Re: The Old Garage Site, Newton Road, Dunsop Bridge BB7 3BB
Approval of details reserved by conditions 4 and 5
Ribble Valley ref 3/2025/0318
UU ref DC/25/1156

We have been passed a copy of the United Utilities consultation letter dated 27th May 2025, and have the following comments and response to make.

Client		The Duchy of Lancaster	
Project		Old Garage Site Dunsop Bridge	
Drawing title		Drainage Proposals	
Drawn	PB	Chkd	Date
Sheet Size	A1	Drawing No.	23120-DR-C-0120
Scale	var	Revision	P9

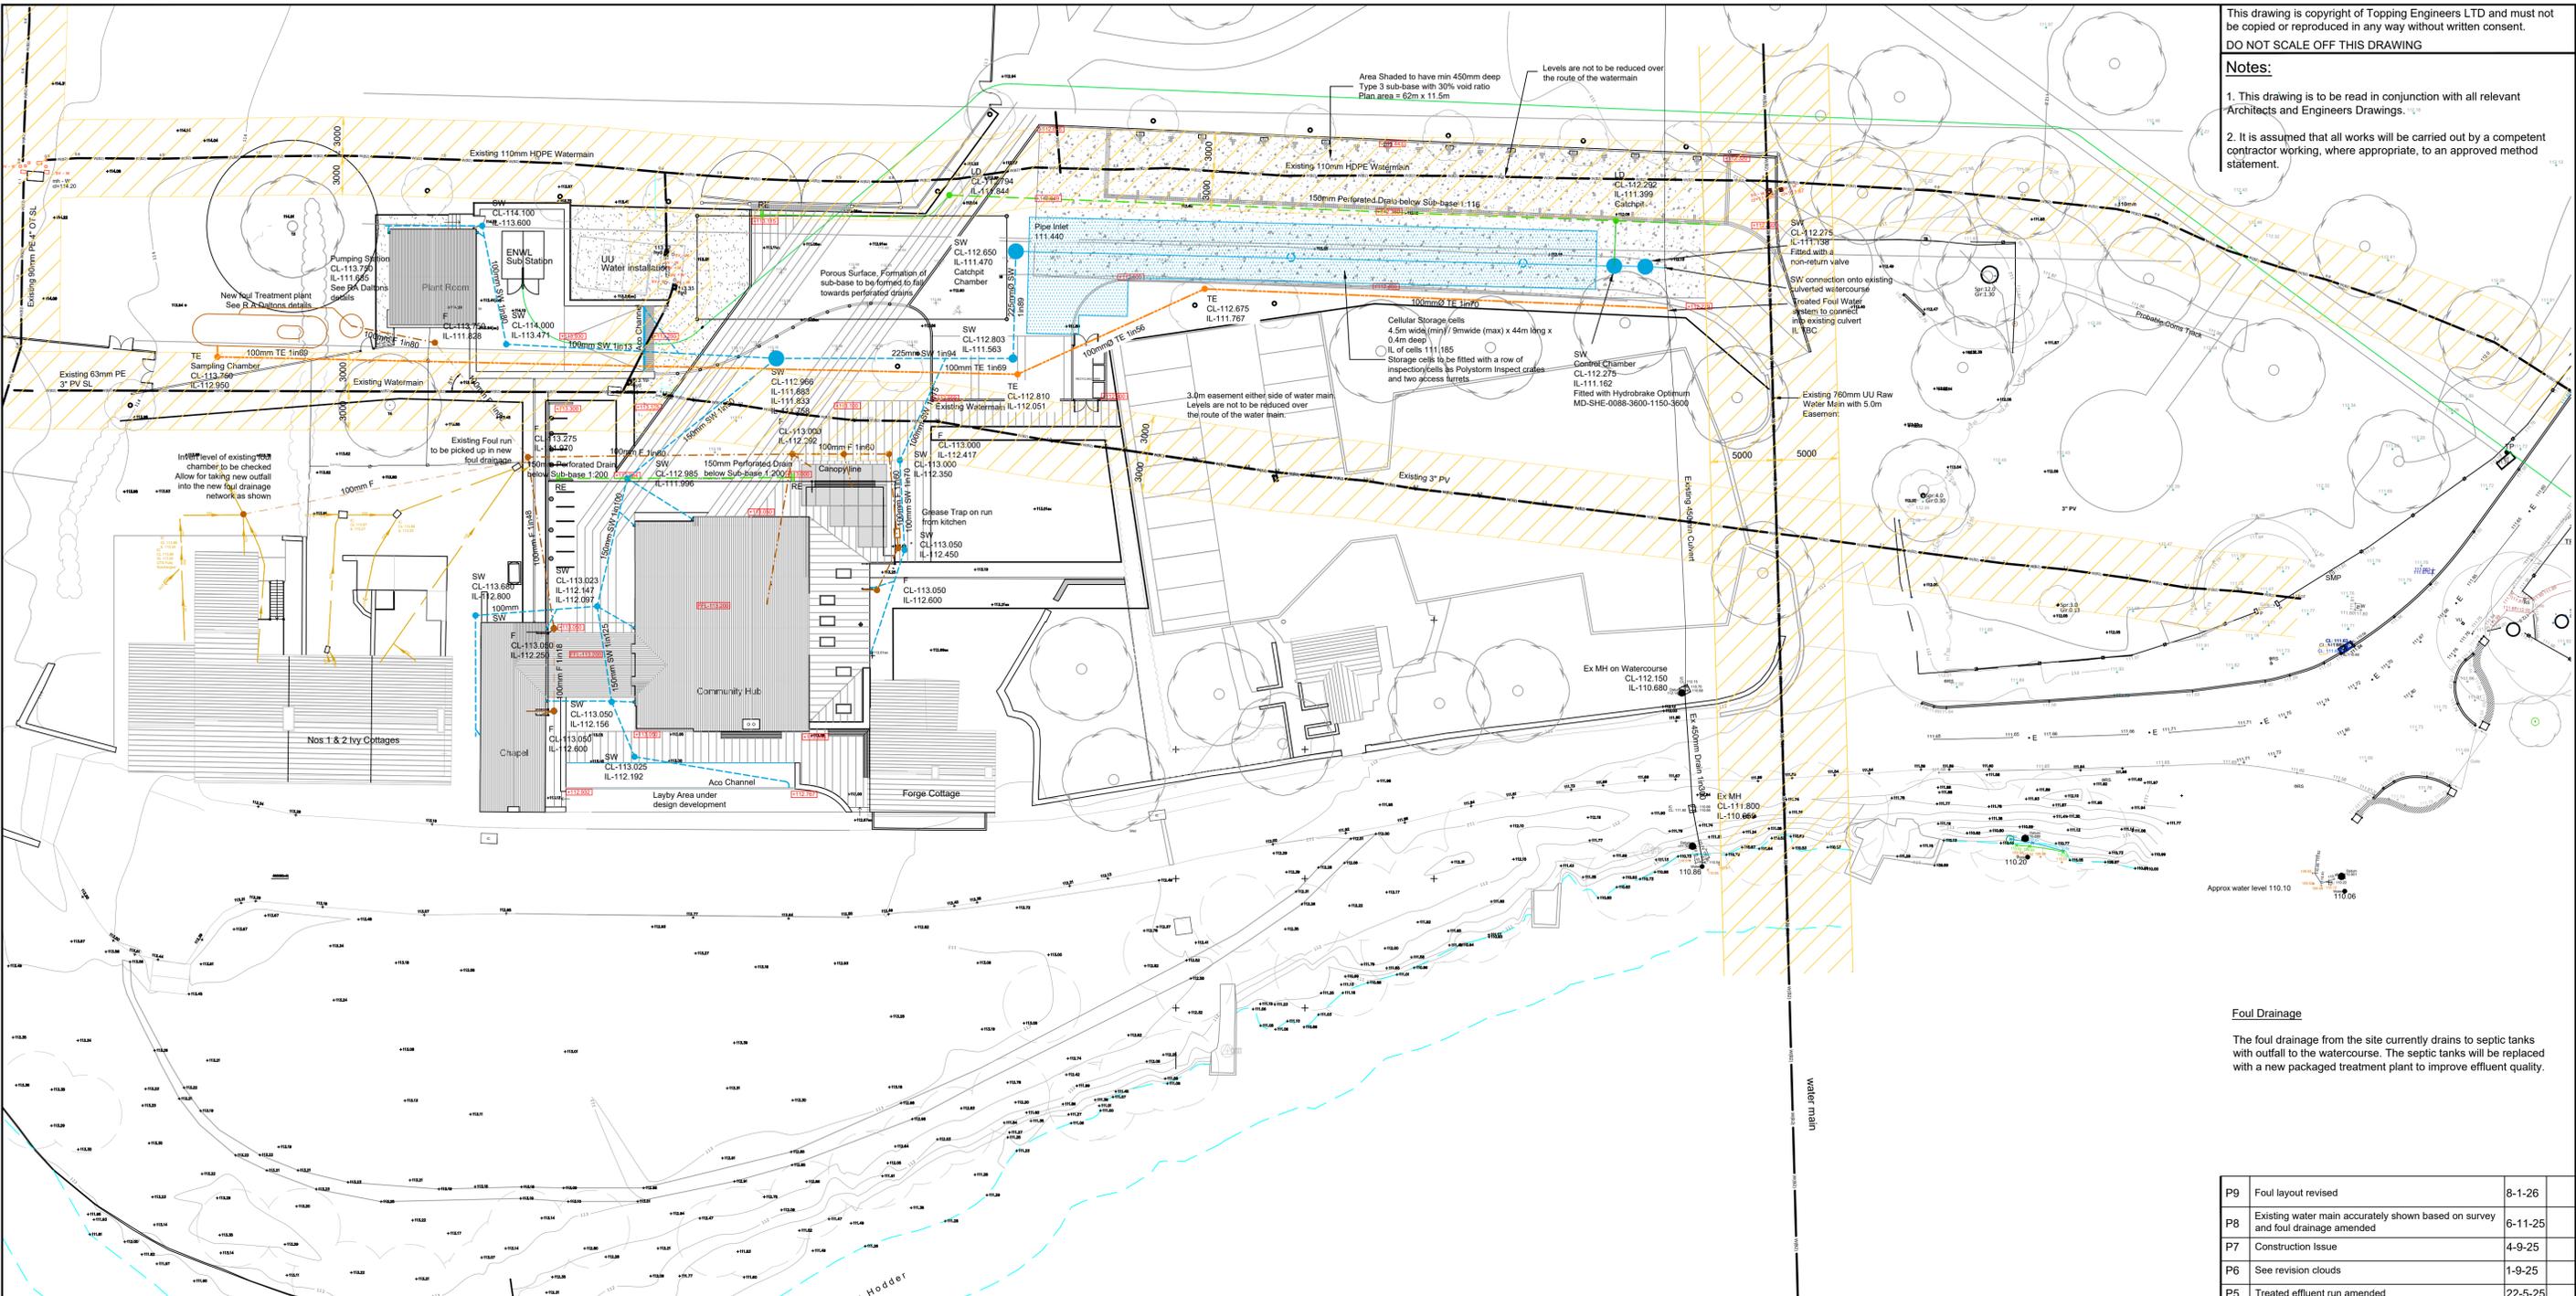
Regarding condition 5, we are not proposing the site drains to the Raw Water Main, but to an existing 450mm diam culverted watercourse that outfalls into the river. The Raw Water Main runs parallel to this culvert.

Regarding condition 4, We have been liaising with Graham Perry and Mark Ryan at United Utilities in order to locate the position of the Raw Water main. This has now been accurately picked up on the survey drawing and superimposed on our drainage plan. The attached updated drawing 23120-DR-C-0120-P6, shows the accurate location of all the UU services on the site. The drainage layout has been adjusted slightly to ensure there are no proposed excavations or adjustment of ground levels within the required easements from your services.
